**Project Name:** Reed School Redevelopment  
**Address:** 19 Libby Street  
**Applicant:** Michael Lyne  
**Planner:** Matthew Grooms

**Project ID:** 2017-234  
**CBL:** 338-K-004

RE: Staff Review Comments for 19 Libby Street – Reed School Redevelopment (2017-234) –  
Planning Authority Review

**TO:** Matt Grooms, Planner  
**FROM:** Lauren Swett, P.E. and Amy LeBel, E.I.T.  
**DATE:** November 20, 2017  
**RE:** 19 Libby Street Peer Review, Level I Site Alteration

Drawing file: 1. Original Plans / C1.0 SITE PLAN.pdf

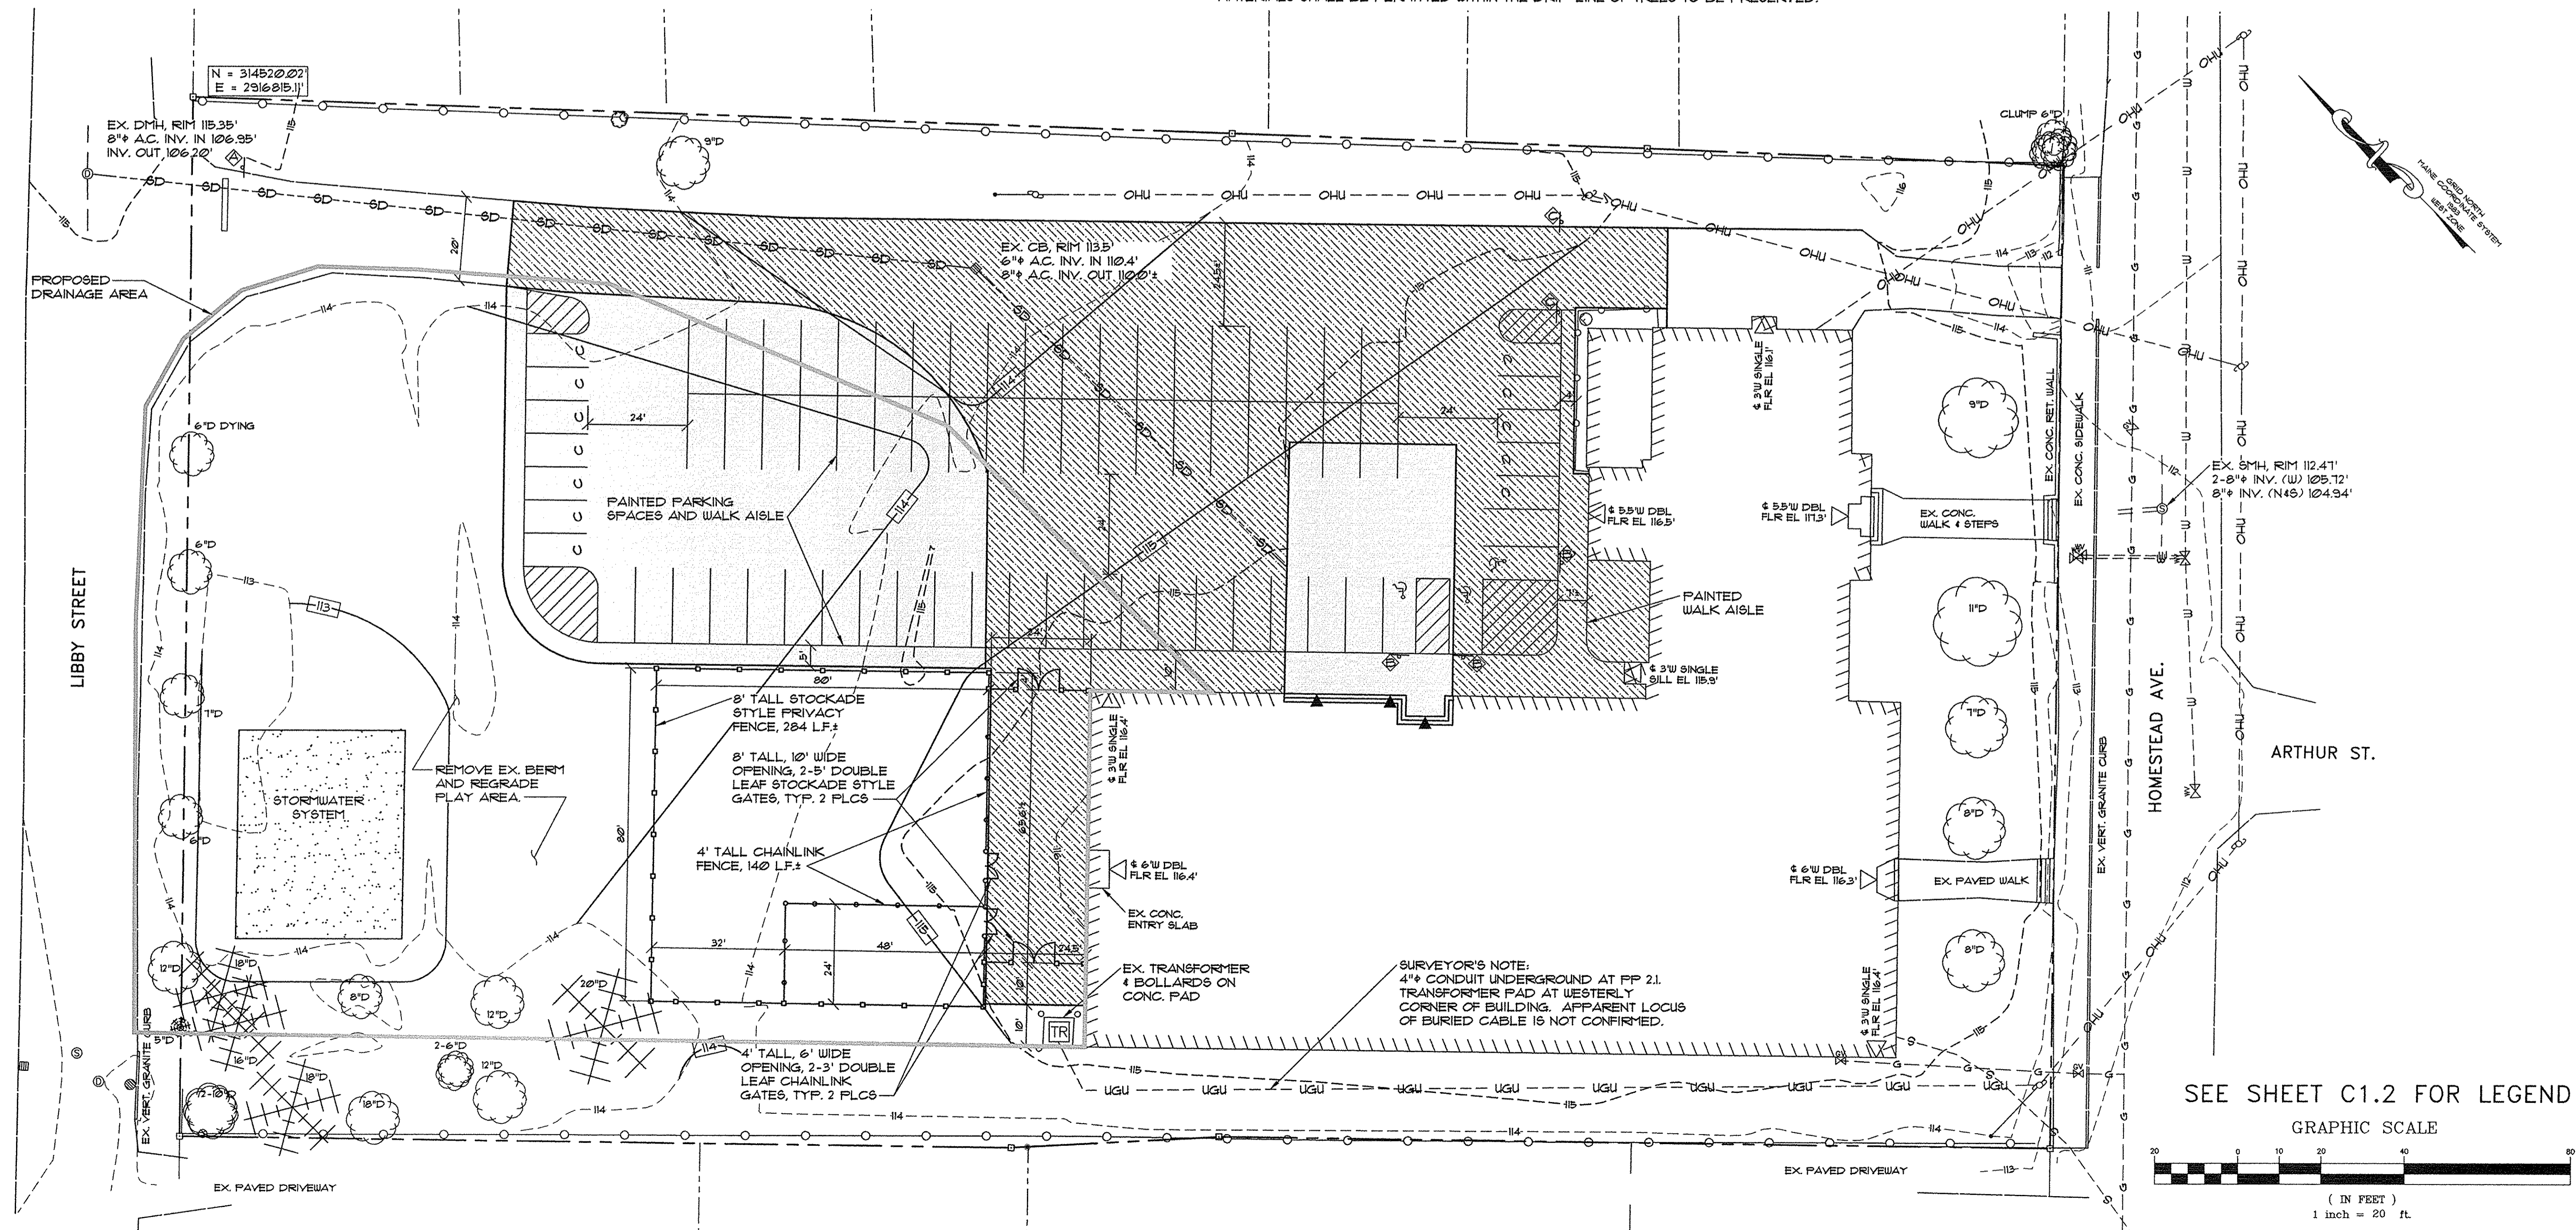
1. The applicant shall provide additional information regarding the proposed playground. Will this feature include pervious or impervious surface? Will neighborhood residents have access to the playground when the school is not in session?
2. The proposed site plan provides significantly more parking (75 spaces) than is required under Division 20, Off-Street Parking Standards. In regards to schools, The city's off-street parking standards require one (1) parking space per room utilized for instruction, which per the provided floor plan would equate to ten (10) required parking spaces. The proposed residential portion would require parking at a rate of two (2) parking spaces per unit, for a total requirement of twenty-six (26) parking spaces, including the sixteen (16)

for residential uses. The applicant's trip generation report appears to indicate an am peak trip generation of 75 trips, though not all of these trips correspond to required parking. Per Section 14-526(a)(4)(a)(iii), the applicant is required to provide a written justification for parking in excess of 10% beyond the required amount.

- 2) The plans should identify what the proposed ground cover is for the fenced playground area.
- 3) Snow storage areas should be provided, or a snow management plan should be described.

- The site plan shows no pedestrian route from Libby Ave into the site and to building entrances, except presumably within the parking lot.
- The plan shows no sidewalk along Libby Street and the applicant does not request a waiver of the sidewalk requirement using the criteria for such a waiver.

- The parking lot layout from a traffic operations perspective appears acceptable. The applicant should document the number of spaces for handicapped parking, compact spaces and general parking required or allowed per the ordinance and/or a parking demand analysis and compare those figures to the supply of each type provided.

- The proposed 5' walkway along the perimeter of the parking lot is have some physical separation from the parking stalls (curb stops, raised curb, grassed/treed area, e.g.) to prevent encroachment of vehicles into the walkway. The width of this walkway may need to be expanded depending upon the means of separation selected; separation by paint only is not acceptable.

7 SOIL FILTER NOTES

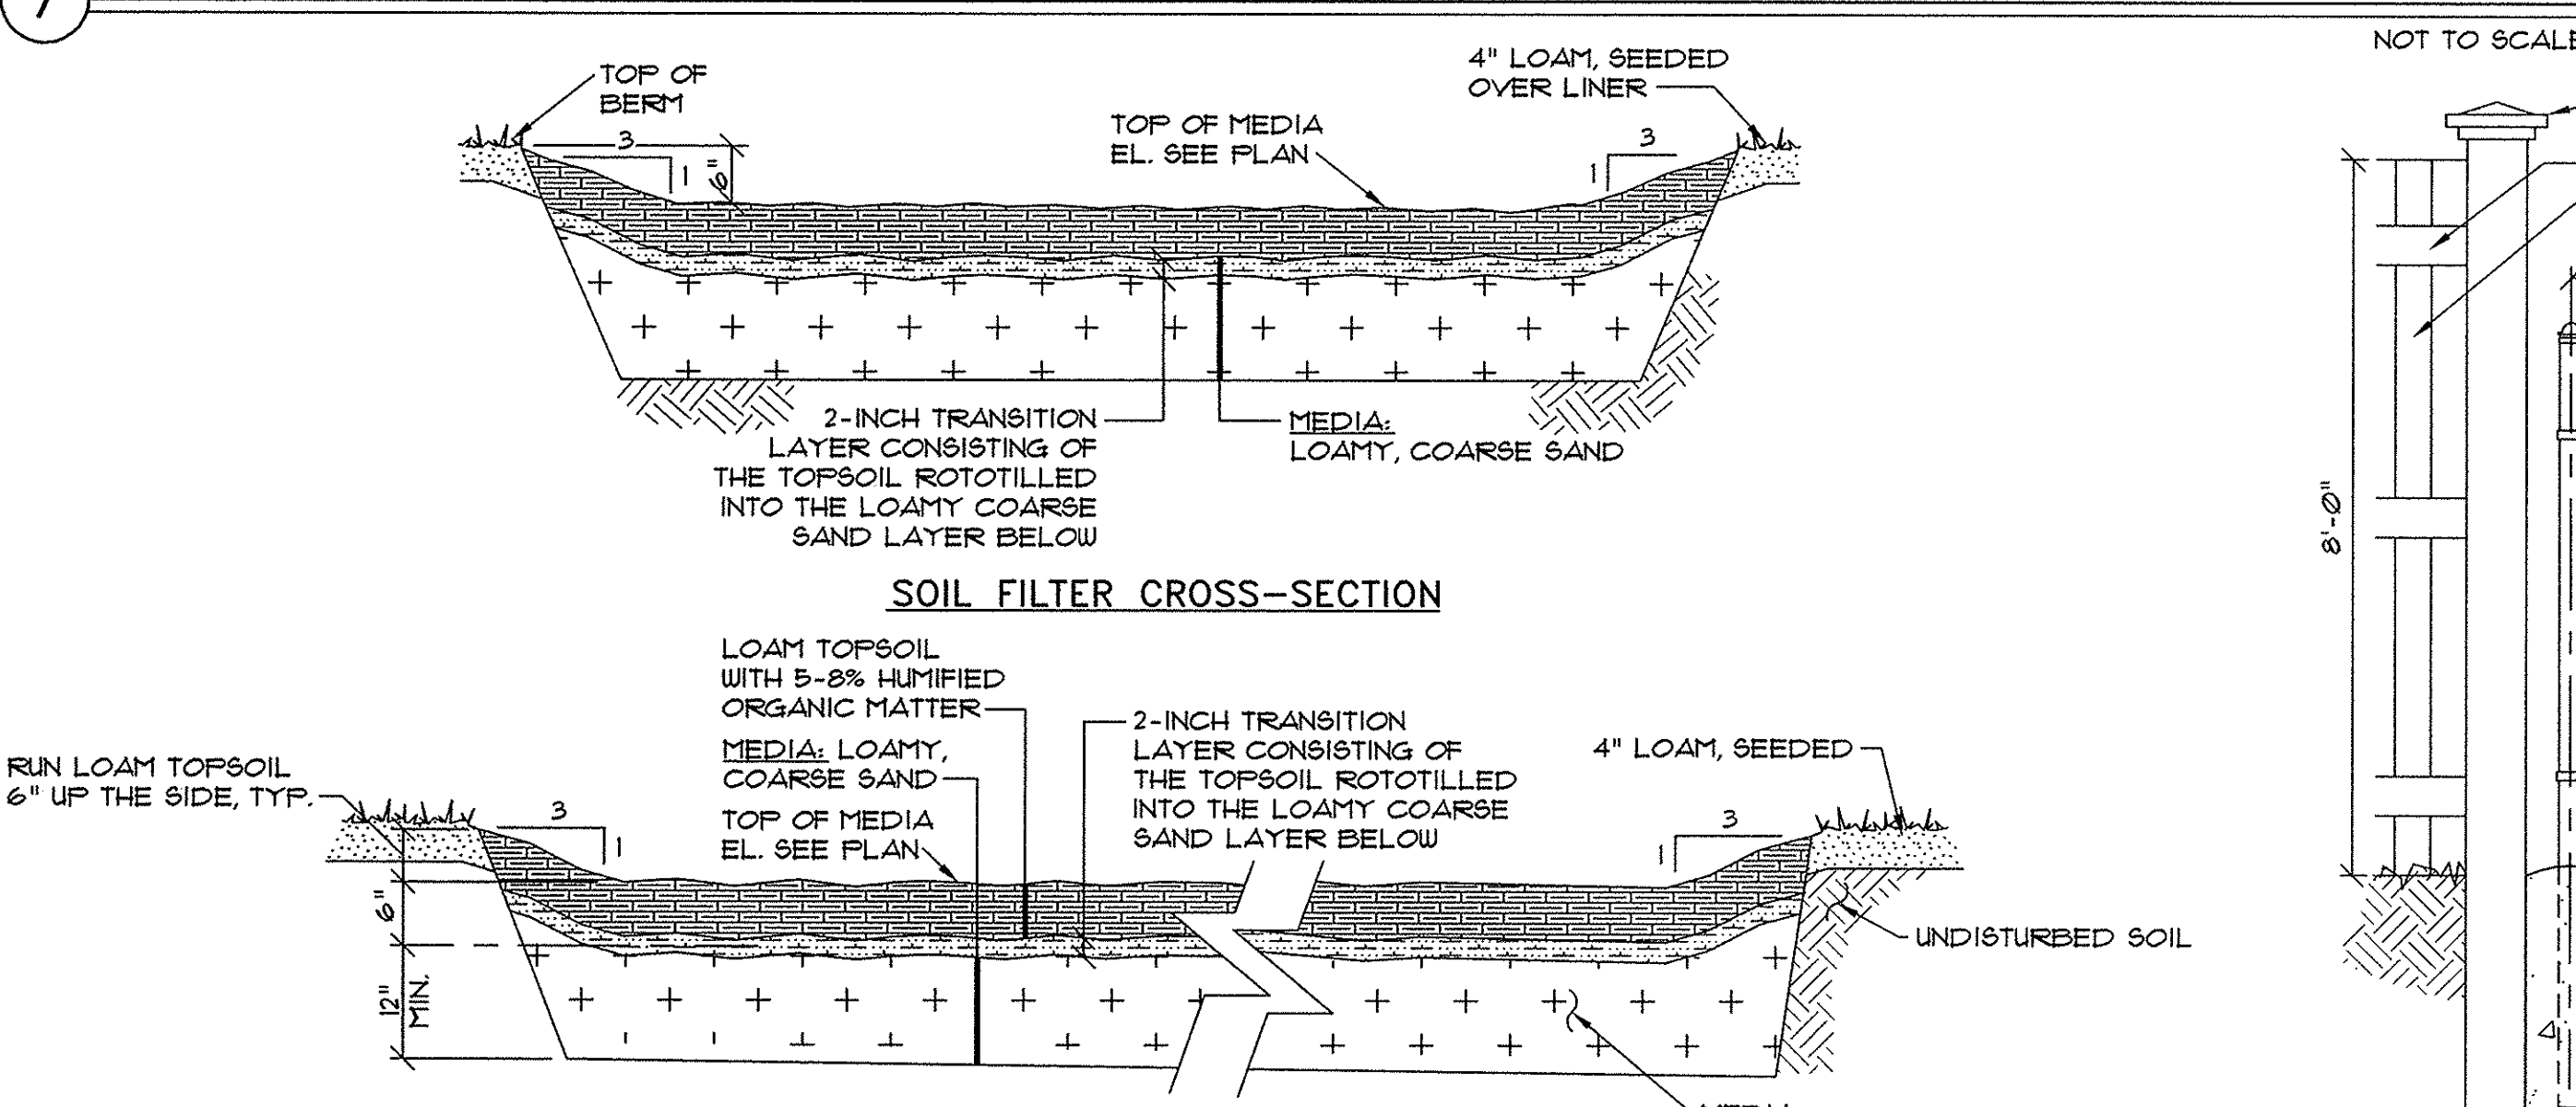
- Provide BMP sizing calculations for the infiltration soil filter.
    - Per Chapter 6 of the Maine Stormwater BMP Manual, pretreatment devices such as grassed swales, underdrained swales, filter strips, and sediment traps should be provided to minimize the discharge of sediment to an infiltration system. Provide a pre-treatment to collect sediment from paved area prior to entering soil filter and provide sizing calculations.

- The only outlet to the stormwater system is exfiltration. An emergency spillway should be provided.
    - The grading at the southwest end of the stormwater system is not complete. A new "14" contour needs to be shown to provide continuous grading around the filter area, and a berm to protect the adjacent paved driveway. This will result in additional impact to existing vegetation in this area.

EROSION CONTROL
PLAN & NOTES

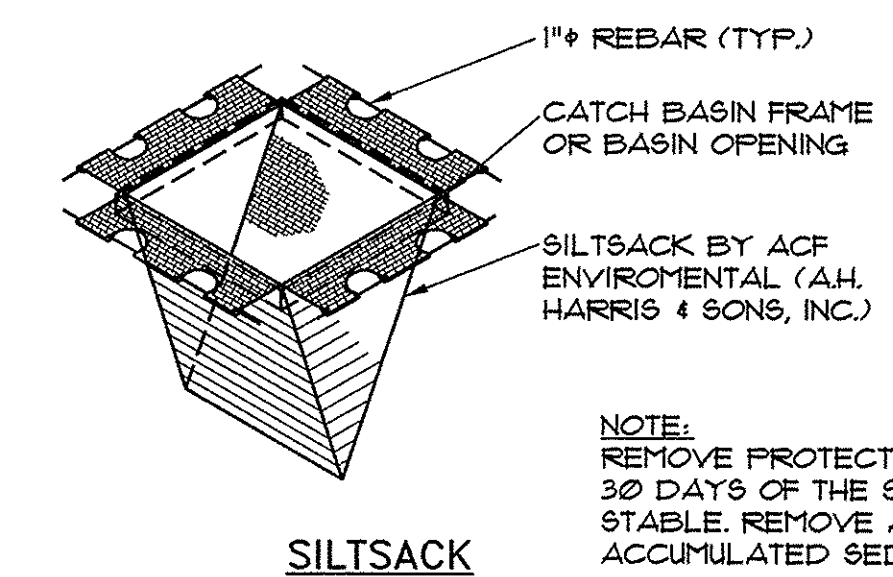
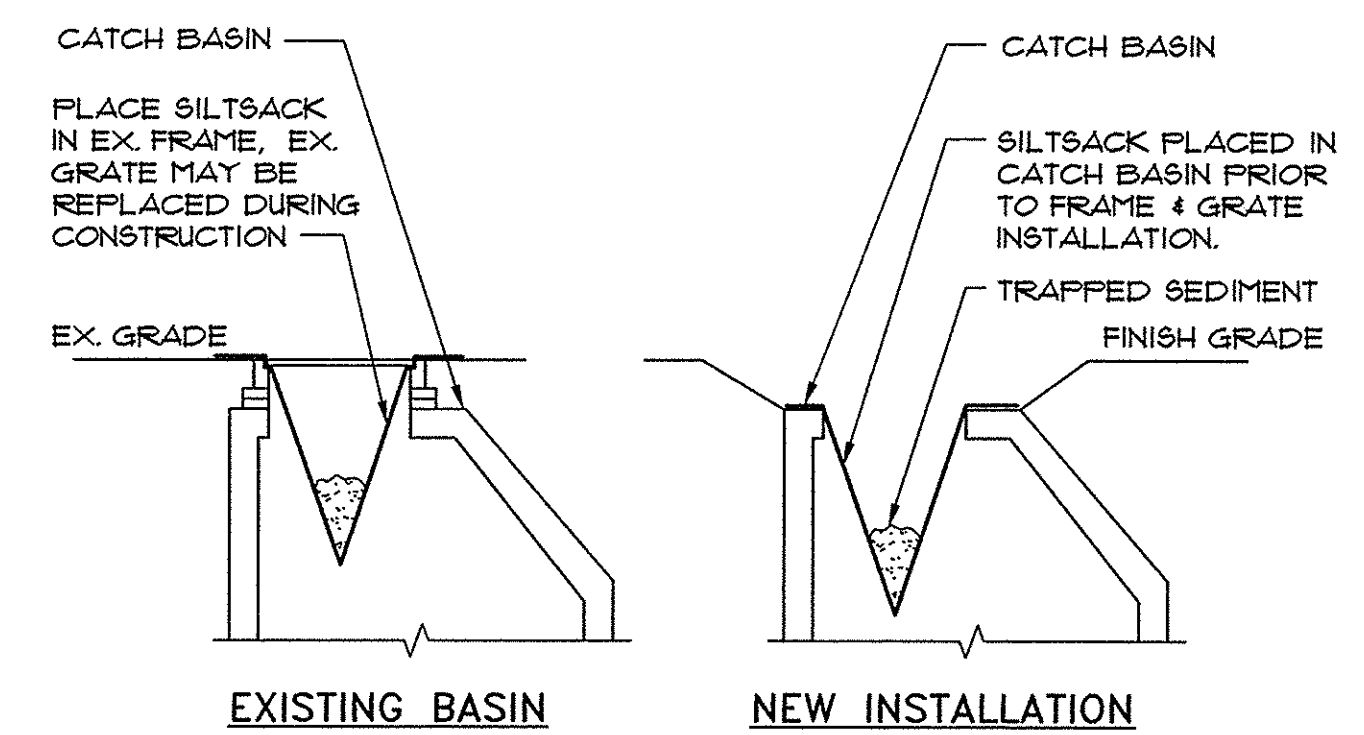
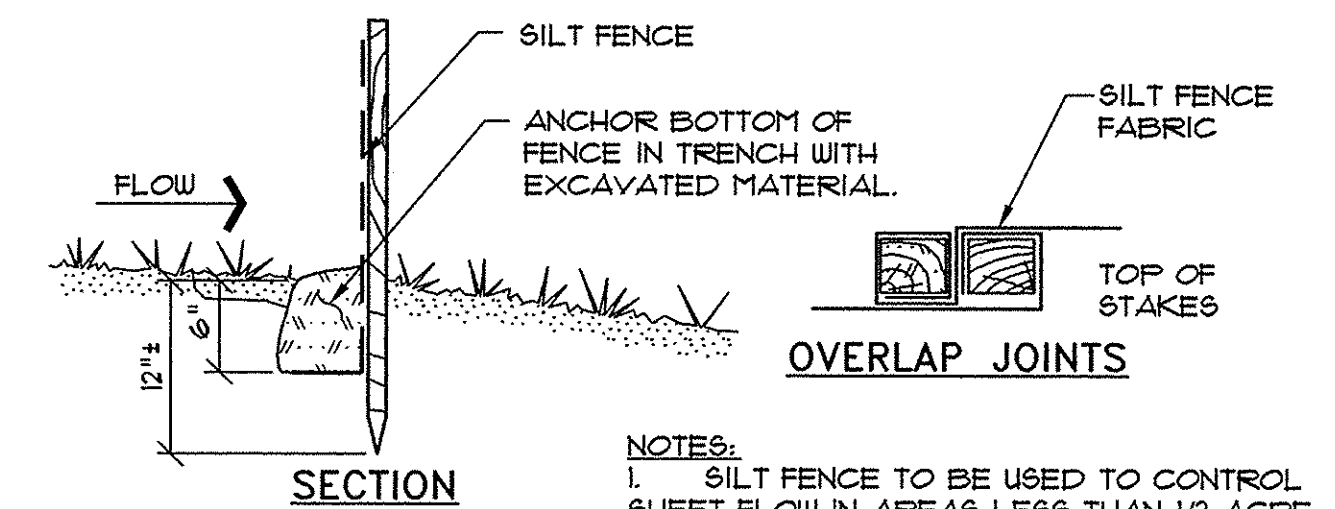
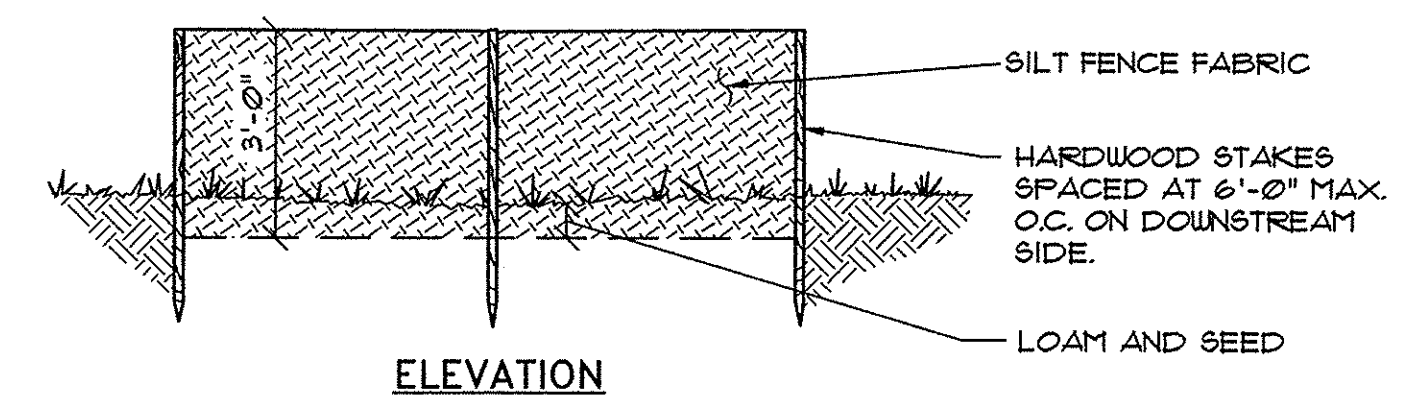
- It appears that there may be a line-type issue for erosion control berm and silt fence on the erosion control plan. Clarify where the erosion control berm and silt fence are to be located.
